Formal Planning Objection

Re: Planning Application 2026/62/90484/E – Change of Use from dwelling to C2 for 4 children, erection of first floor extension and front porch, internal and external alterations.

Property: 143 Church Lane, Gomersal, BD19 4QN

Alterations and Extensions to  
143 Church Lane Gomersal, Cleckheaton,  
BD19 4QN.

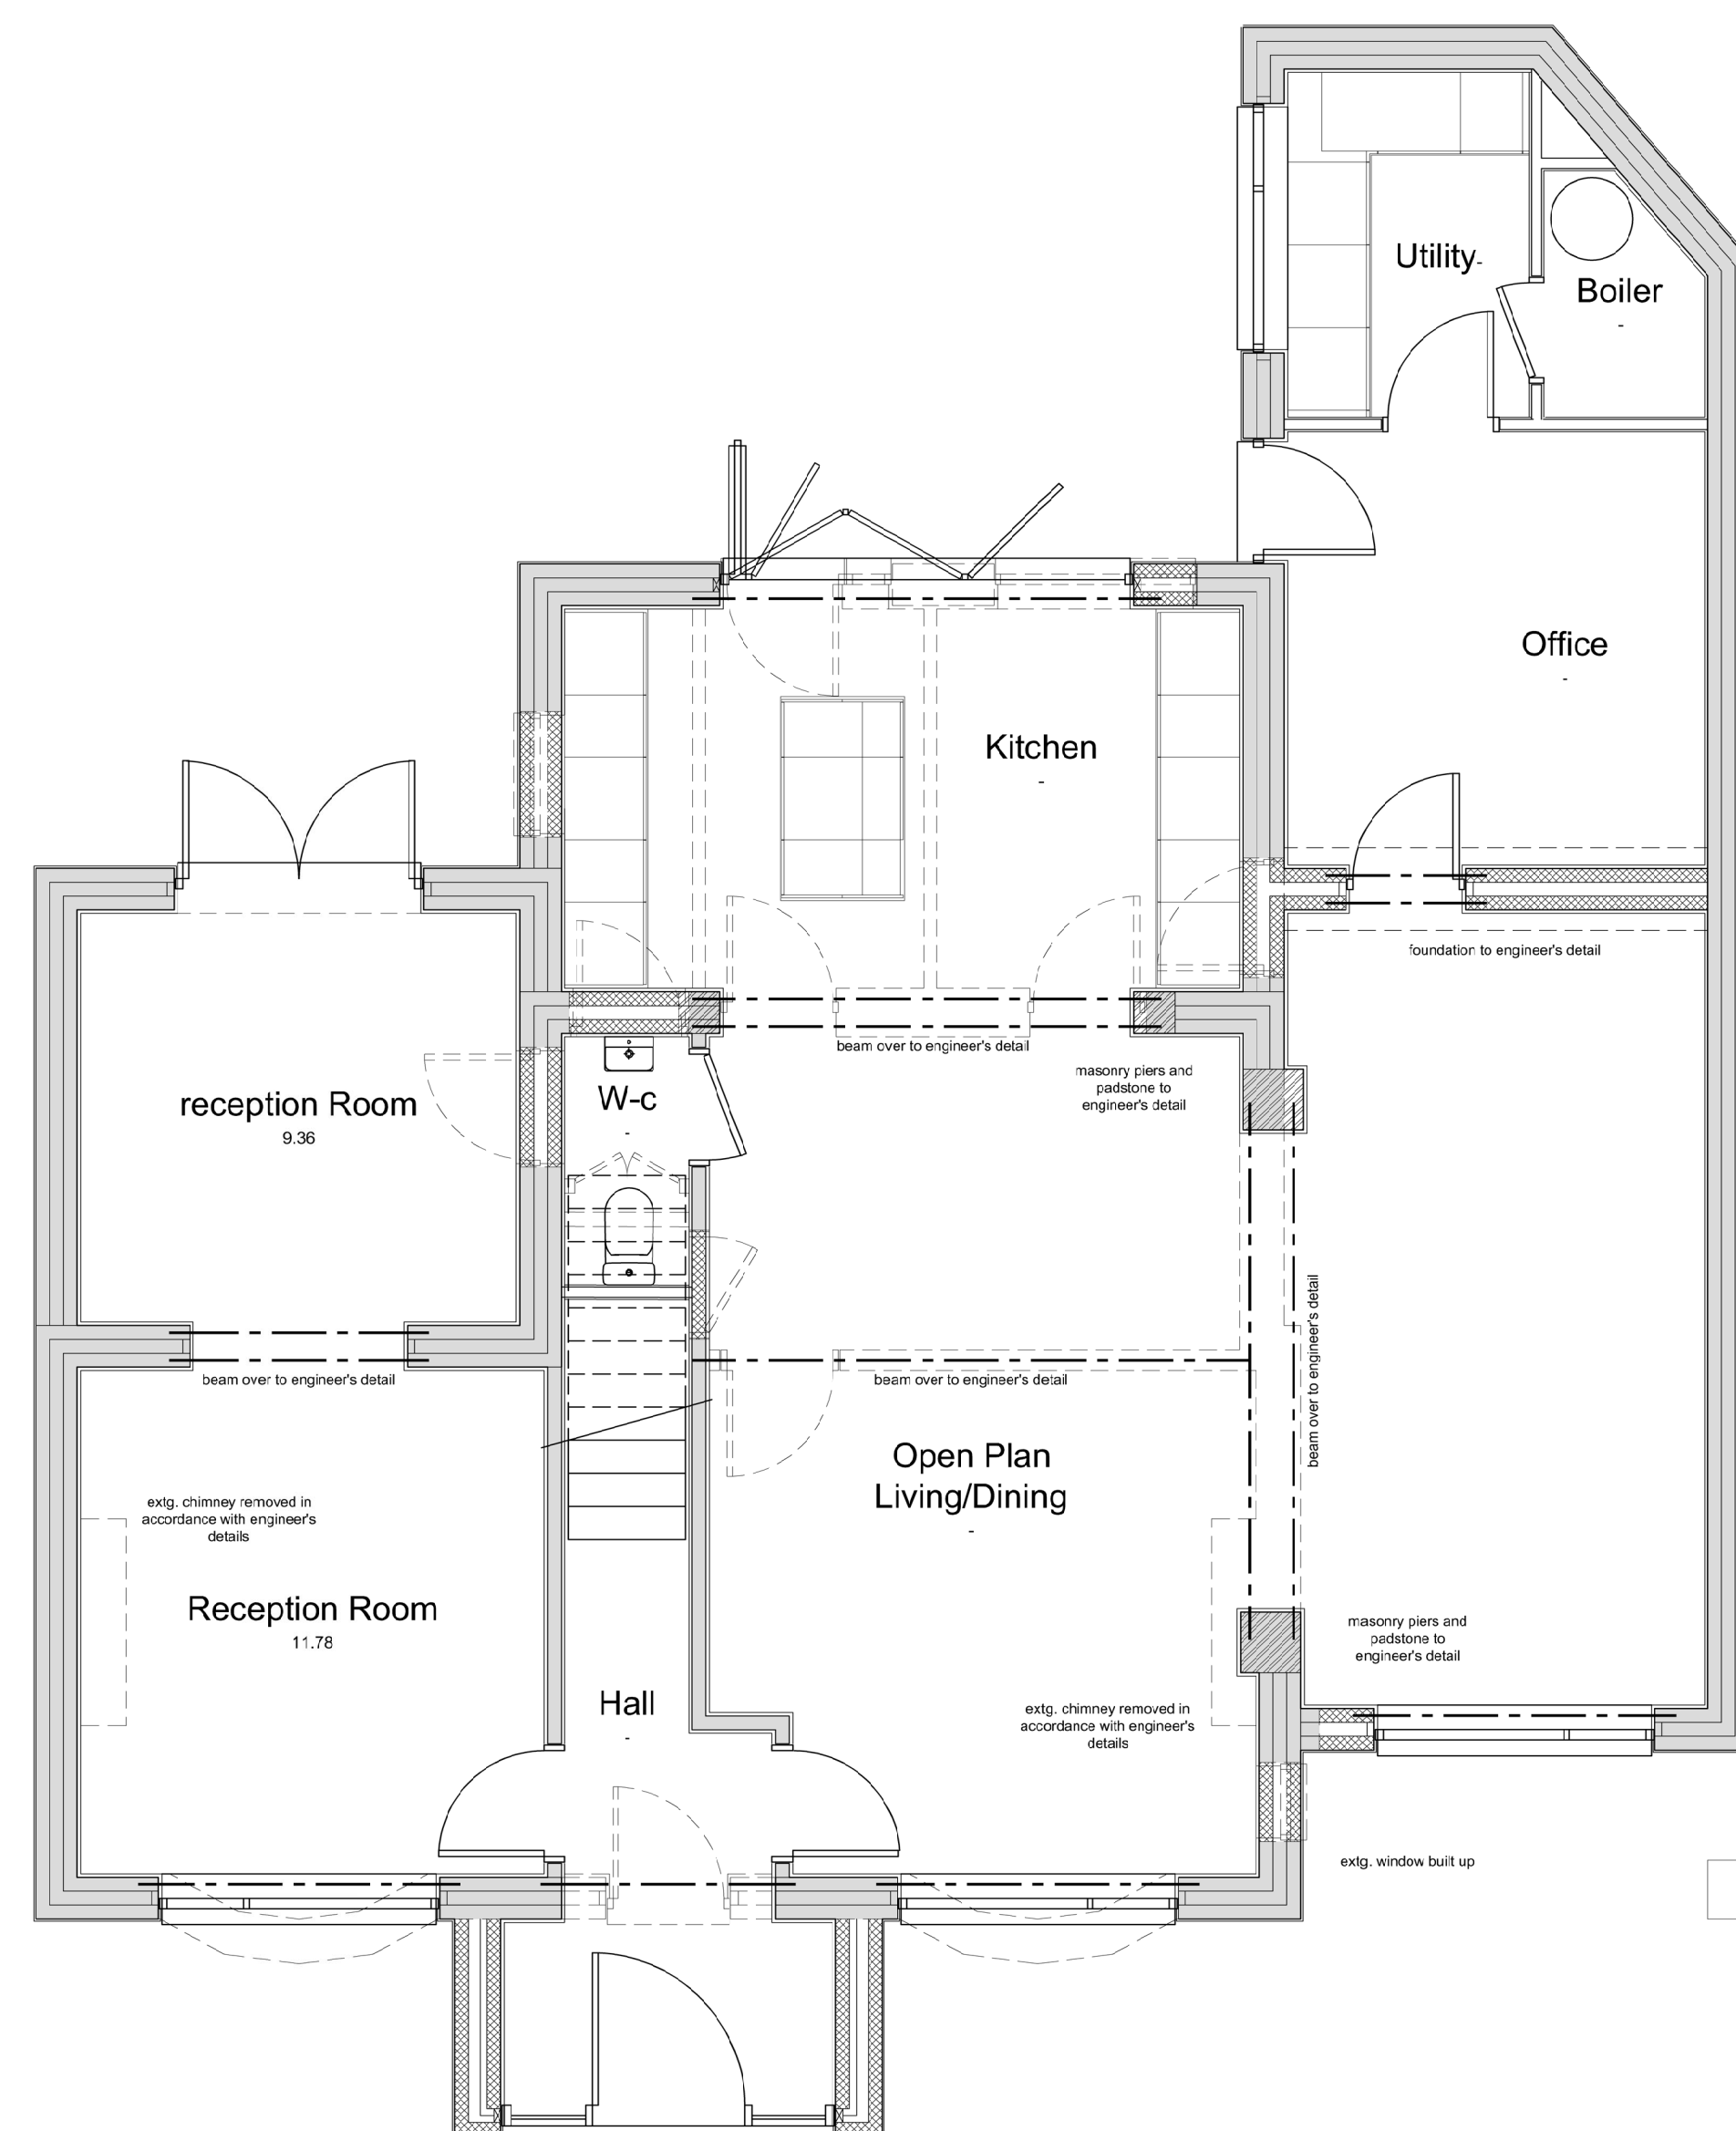
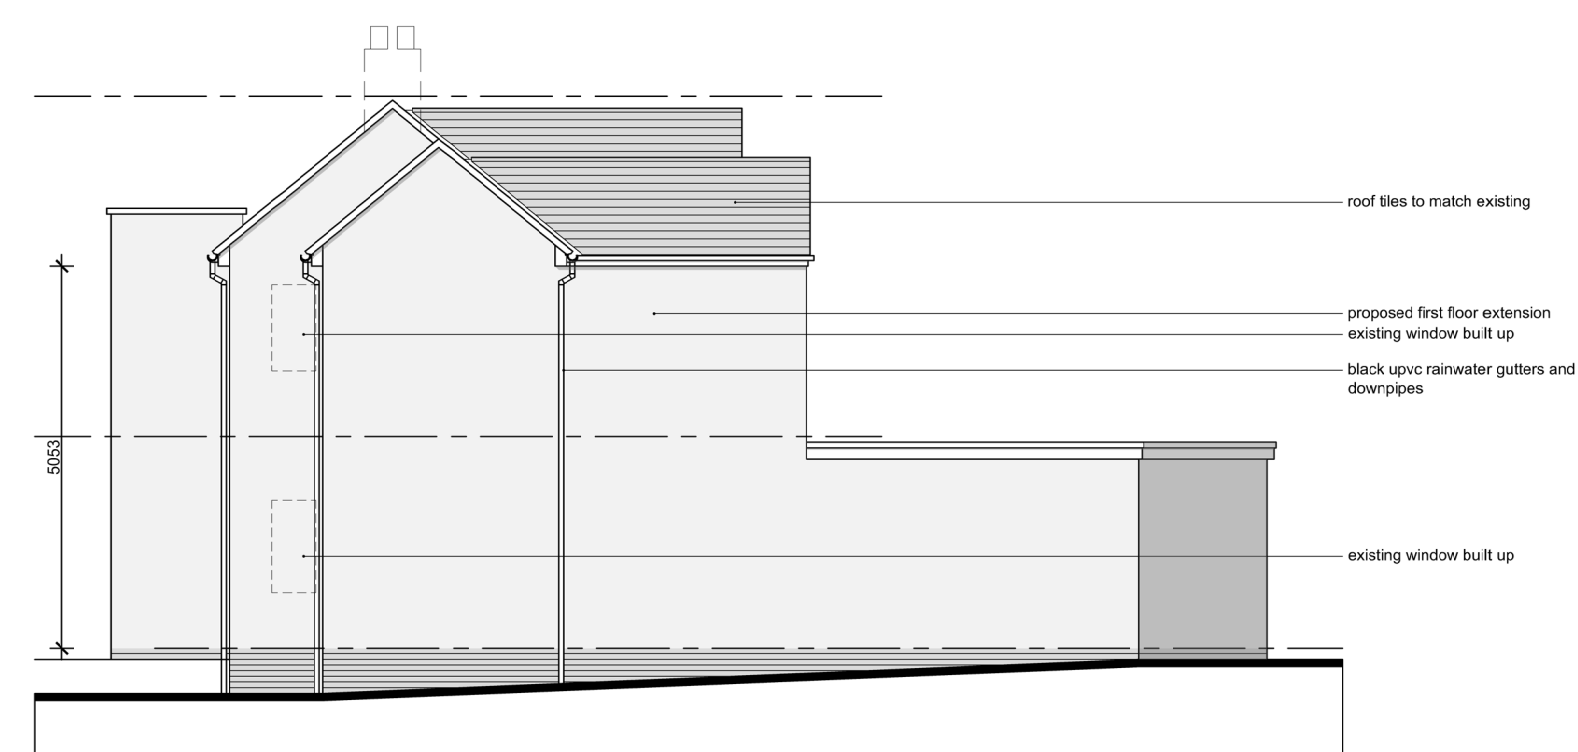
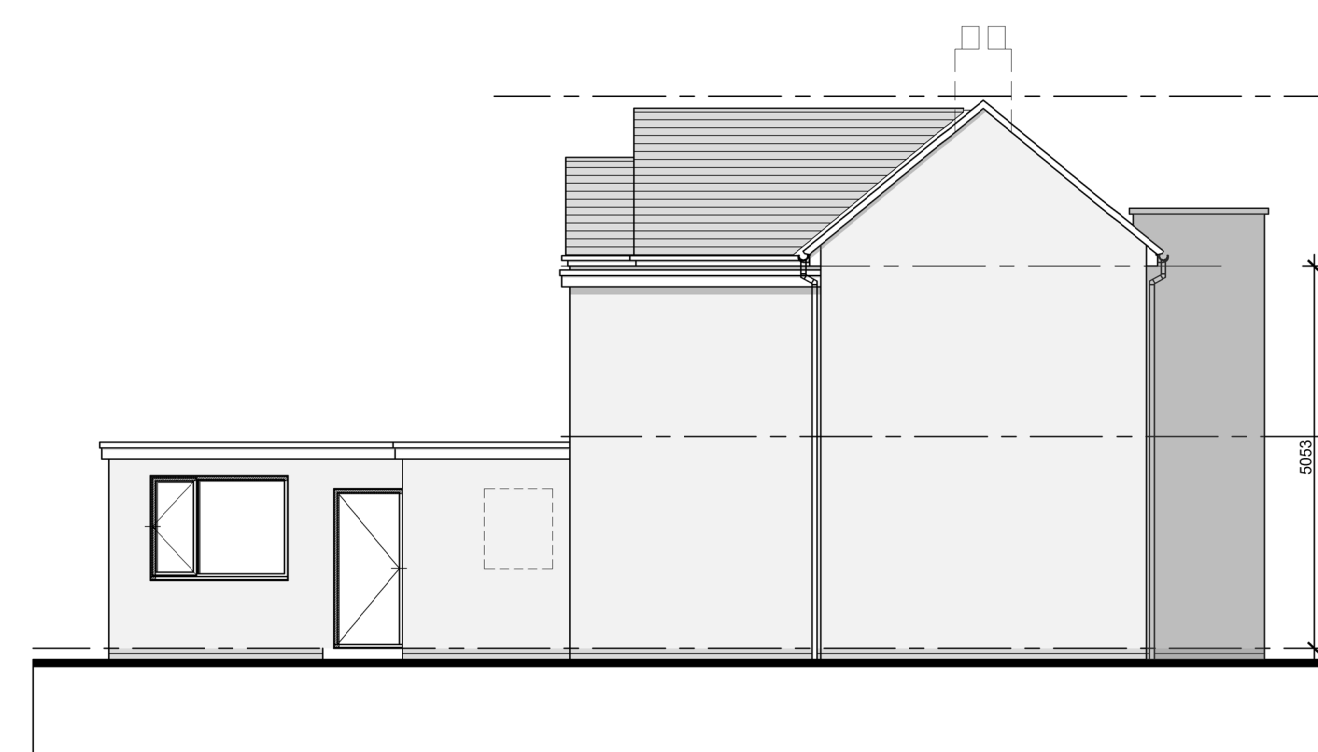
we have significant concerns regarding privacy and overlooking. The layout of the property, combined with its large floor-to-ceiling windows on the front elevation and the positioning of upper-floor circulation spaces such as the landing, would result in clear and direct sightlines towards neighbouring homes and gardens. The proposed use would involve multiple residents and staff regularly occupying these areas throughout the day and night, which would substantially increase the potential for overlooking compared to the existing use as a single private dwelling. This would materially reduce the level of privacy currently enjoyed by neighbouring properties, particularly given the close proximity between the two houses. Policies within the Kirklees Local Plan and national guidance within the National Planning Policy Framework require development proposals to safeguard the residential amenity of neighbouring occupiers and prevent unacceptable levels of overlooking or loss of privacy. In our view, the proposed change of use would significantly intensify activity within the property and create a harmful level of overlooking and loss of residential privacy for adjoining residents.

The property plans propose a very large floor-to-ceiling window on the front elevation which directly faces the public highway.

This design would leave residents, including potentially vulnerable children, highly visible to the public when occupying the entrance hall or upper landing areas. Such a lack of privacy may be detrimental to the emotional wellbeing and safeguarding of the residents themselves.
